KITITITAS COUNTY

MEMORANDUM

TO: All Staff
FROM: Justin Turnbull, County Surveyor 
DATE: November 30, 2017
SUBJECT: County Survey review of Prelim Long Plat LP-17-00007 (Swauk Valley Ranch)

**SHEET 2**

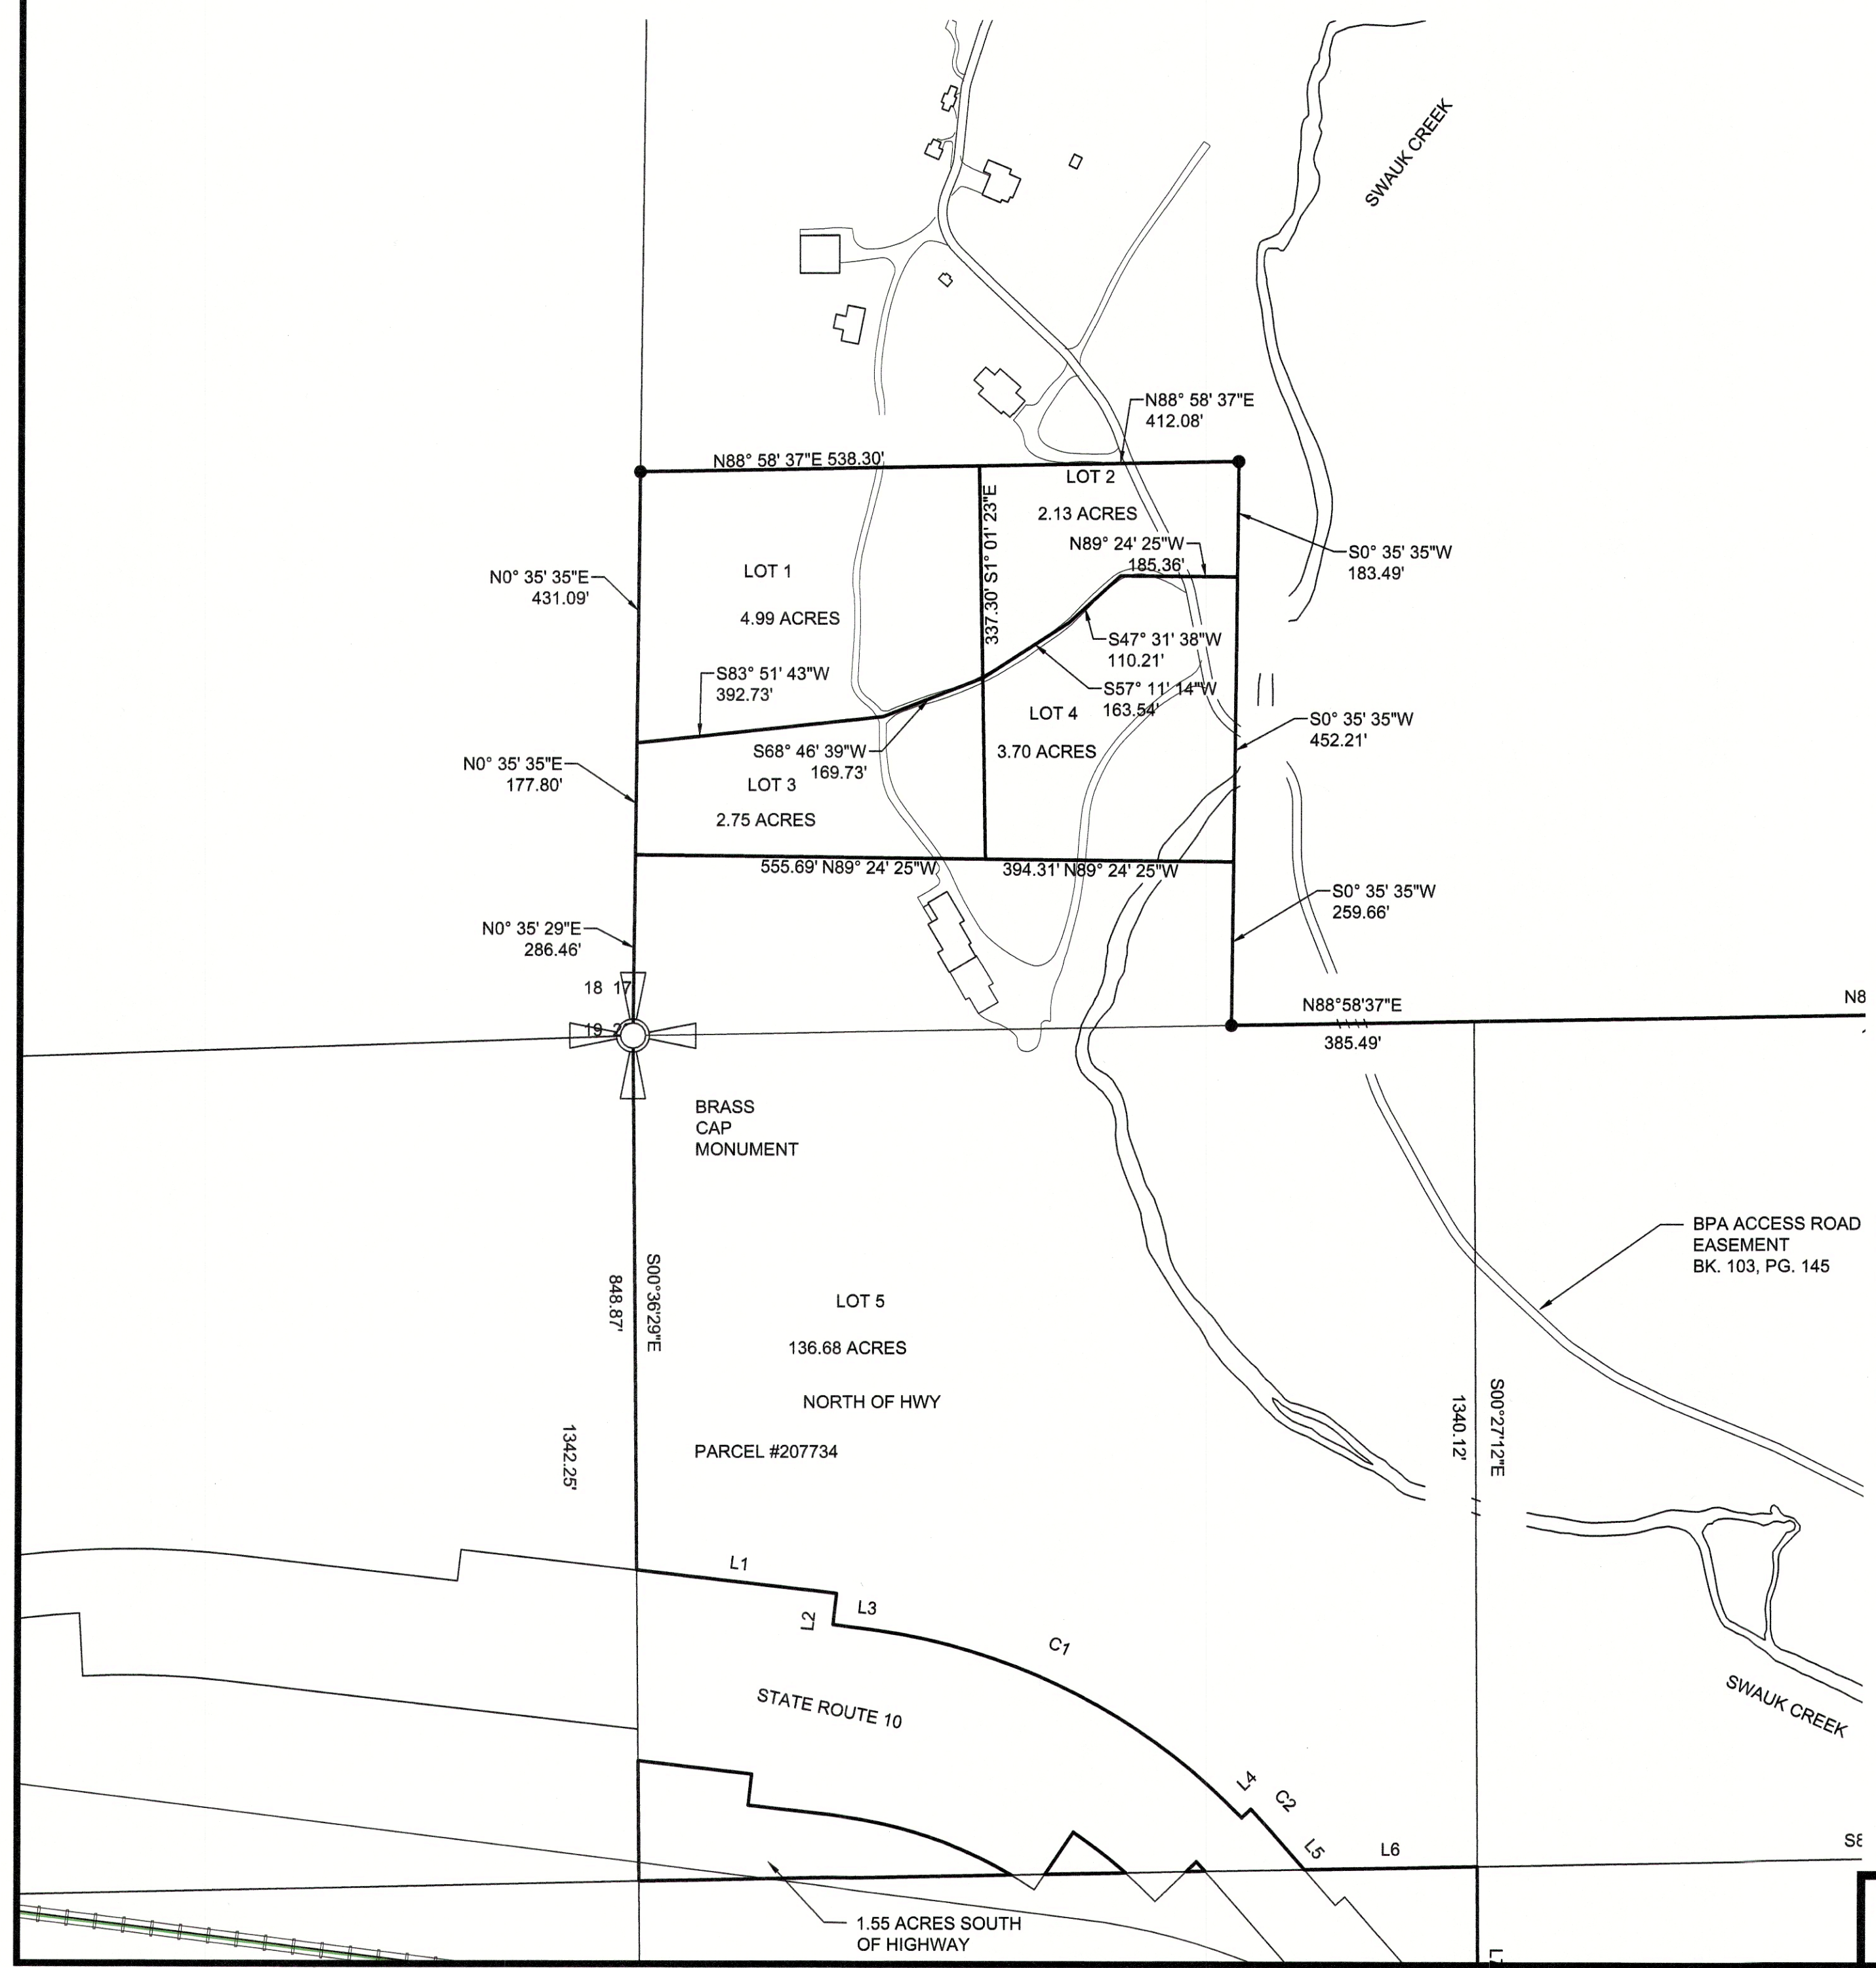
17. Division lines of new lots should be staked in the field.
18. Adjacent survey North of parcel should be labeled (B:41, P7)
19. Sections identified at section symbol are misaligned.
20. The portion of the property lying south of the highway should be delineated.
21. The distance from existing building corners to existing and proposed lot lines should be shown.

**SHEET 1**

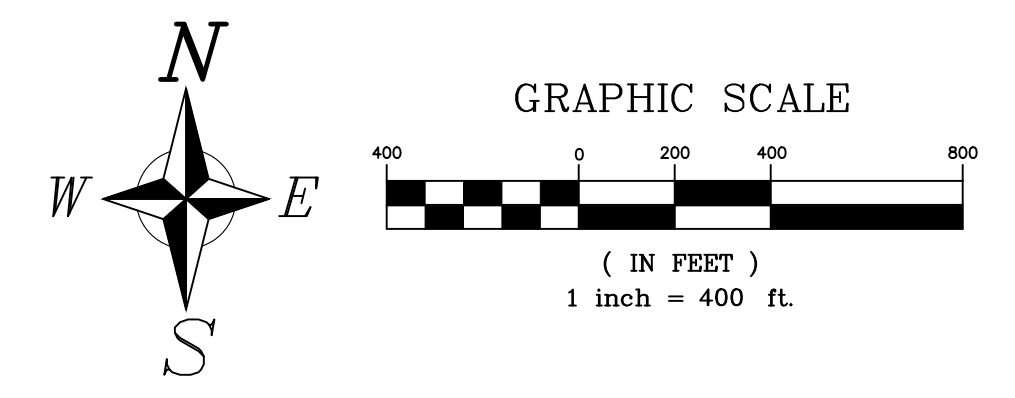
10. A Vicinity Map should be shown.
11. A standard signature block will need to be shown.
12. ~~Utility providers or a statement identifying how utilities are to be addressed (water/sewer/electrical/drainage)~~ (not survey related, see note at end)
13. Set corners shown are at the wrong scale.
14. The access easement should be addressed as existing or herein dedicated. If existing, the recording number should be included, and if dedicated, the position should be mathematically retraceable.
15. The BPA access road should be identified as where it begins and the 40' Access easement ends. (or overlaps identified).
16. Adjacent survey North of parcel should be labeled (B:41, P7)
